# CITY OF ALBUQUERQUE

January 14, 2019

**RE: Luna Vita Subdivision  
Grading and Drainage Plan  
Engineer's Stamp Date: 12/28/18  
Hydrology File: C19D066**

1 SECTION AT PROPERTY LINE
Scale: 1:5

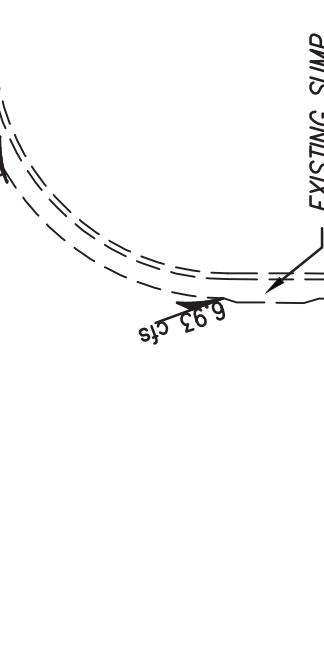
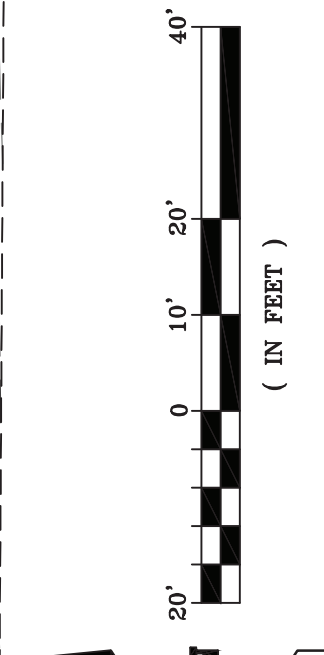
14. Please label Wilshire R.O.W. in Section 1 and Louisiana R.O.W. in Section 5.
15. Please provide all footers in the retaining walls in all sections. Per DPM Ch. 22.5.B, grading and construction of retaining walls at or near the property line must demonstrate that the adjacent property is not damaged or its use constrained. Any such encroachment by the wall or grading must be accompanied by written permission of both landowners.
